Recommendation Report for Planning Permission for Works or Extension to a Dwelling

REF NO: BE/30/20/HH

LOCATION: 1 Homing Gardens
Bersted
West Sussex
PO22 9AJ

PROPOSAL: First floor extension & re-positioning of boundary wall (Re-submission of BE/113/19/HH). This application affects the setting of a listed building & affects the character & appearance of the North Bersted Conservation Area.

sheet 5 of 5

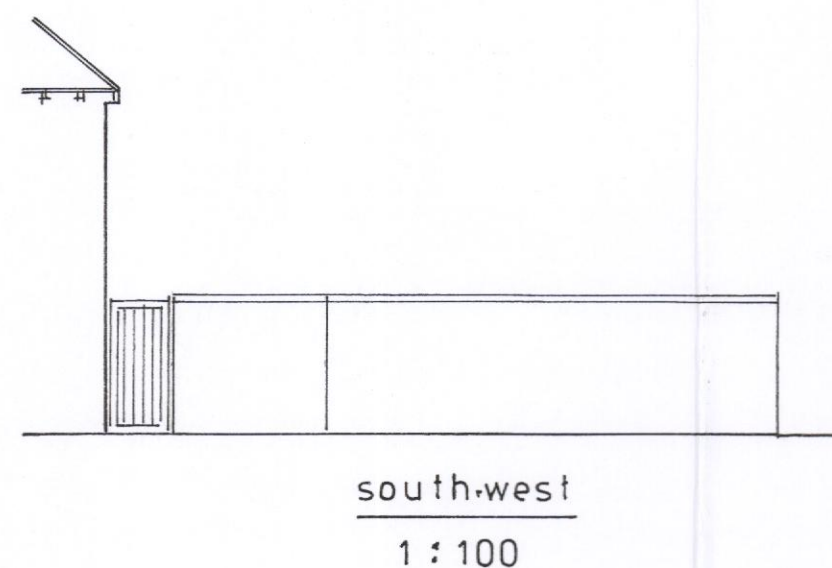
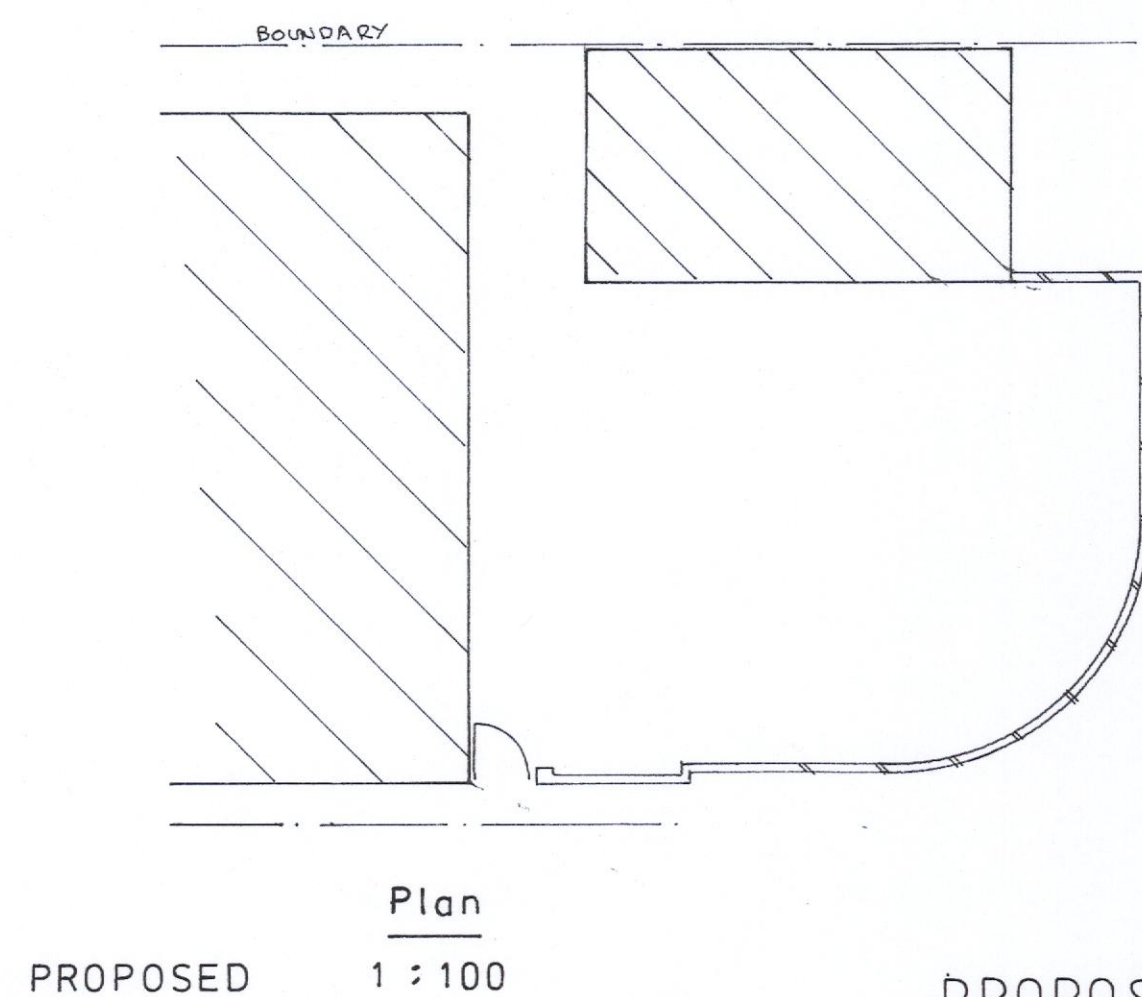
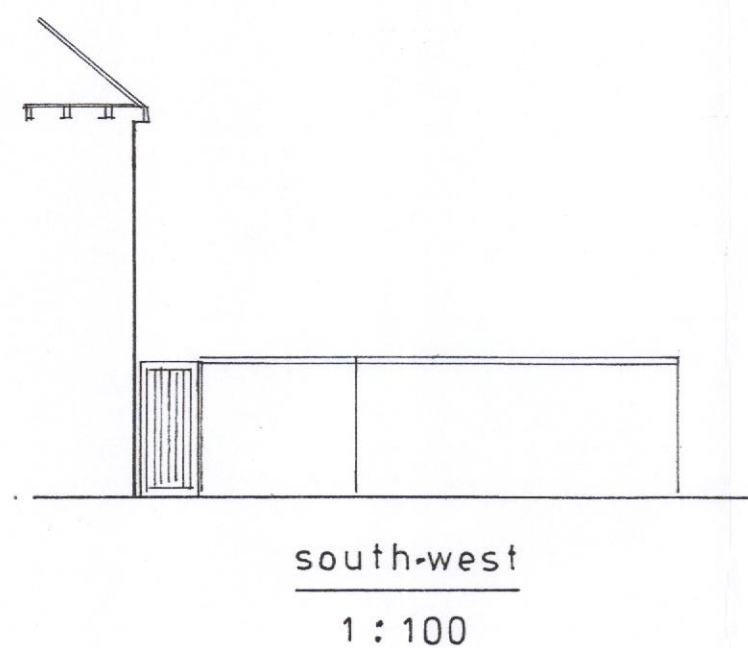
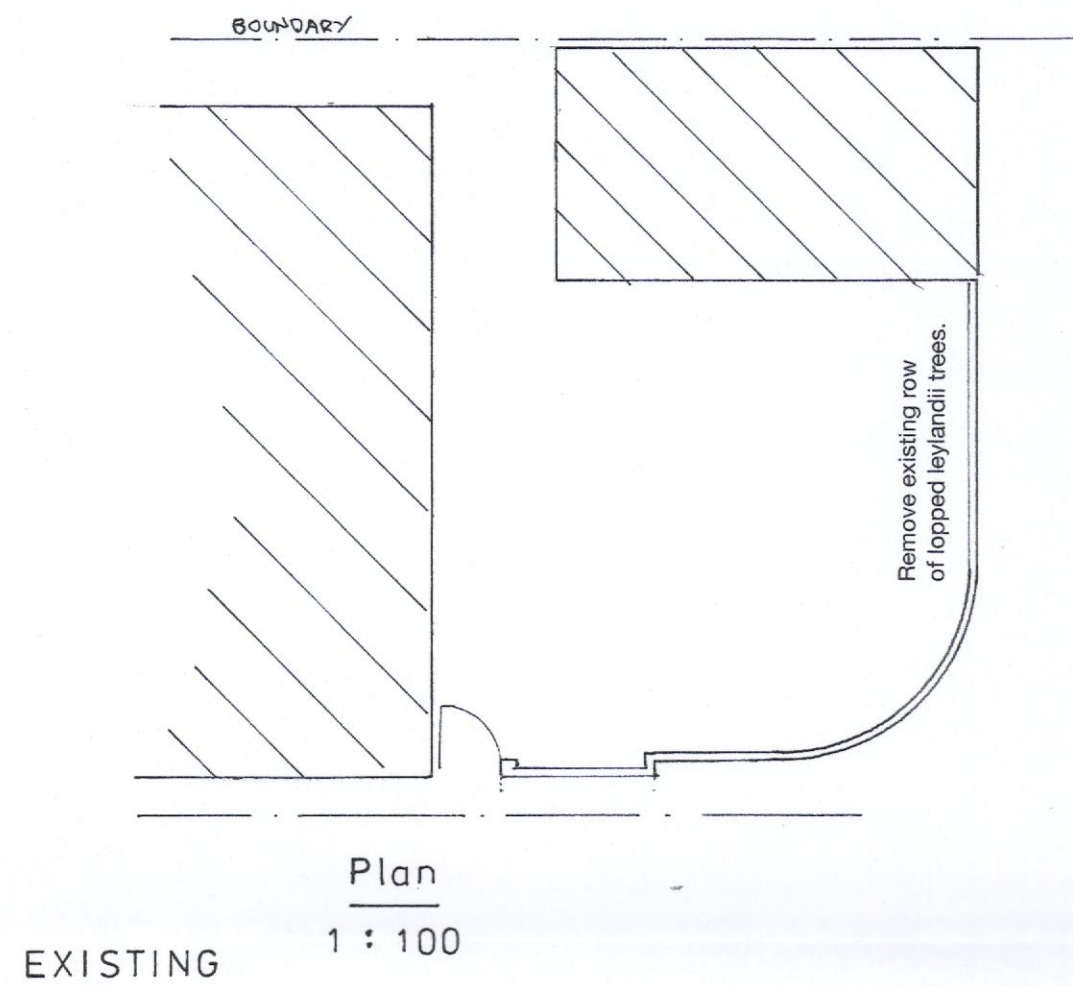
- Whilst it is unfortunate that there would be a loss of some greenery in this location, it will not unduly harm the character of the small road it is facing, or the local area.

The re-positioning of the boundary wall is not considered to have any significant impact on the street scene, whilst losing hedging is unfortunate it is not reason for refusal. The proposed wall is considered in accordance with D DM1.

sheet 2 a of 5

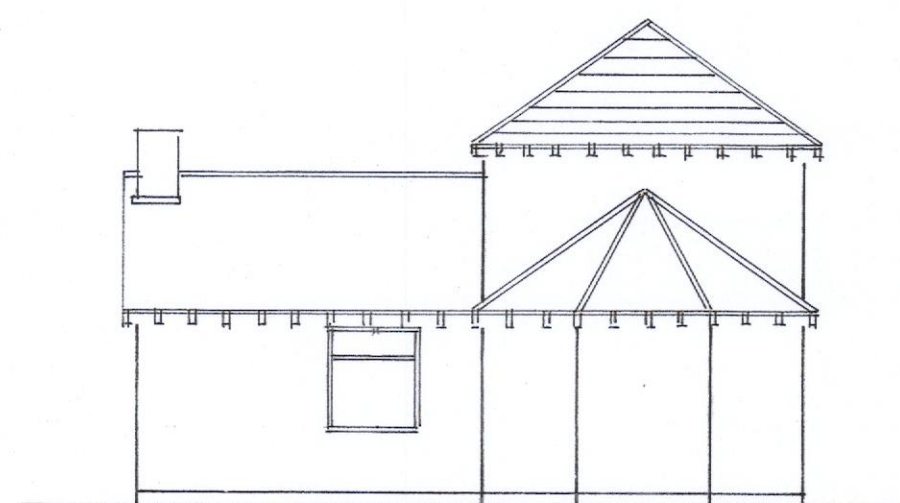
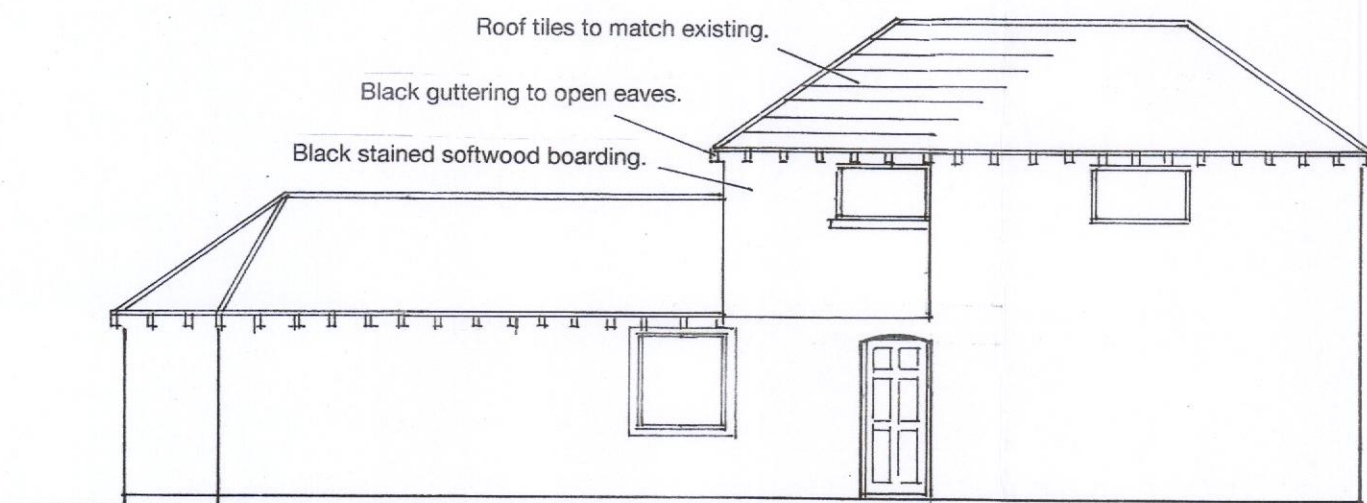
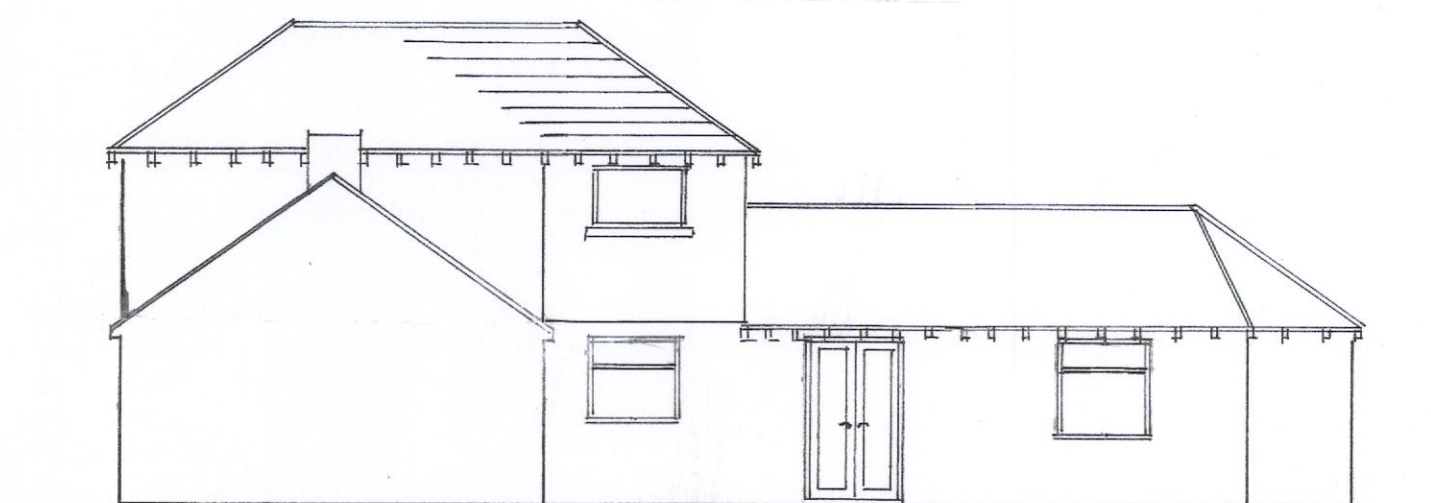
Amended plans have had the advice of the Conservation Officer and reduced mass of the building to something less obtrusive to the Conservation Area as a whole. This is a sensitive area and a sensitive position within in the Conservation Area and it is regretted that cement boarding is to be used in the construction of the extension rather than tile hanging which would coherence to the area by echoing other modern building on the opposite corner. Should this extension be approved, consideration should be given to this rather than boarding.

- Note plans indicate that stained softwood boarding is to be used, whilst the Design and Access Statement refers to Marley Cedar Boarding. Please can the correct material be confirmed?

- Would the cladding cover the entire of the first floor?
- Changes proposed to a window and a door are considered acceptable and will not cause harm.
- Whilst the existing building is considered to sit very close to the listed building and has an impact upon how it is seen/experienced, it is considered that the size of the proposed extension is now such that it will not cause any further harm to the listed buildings.
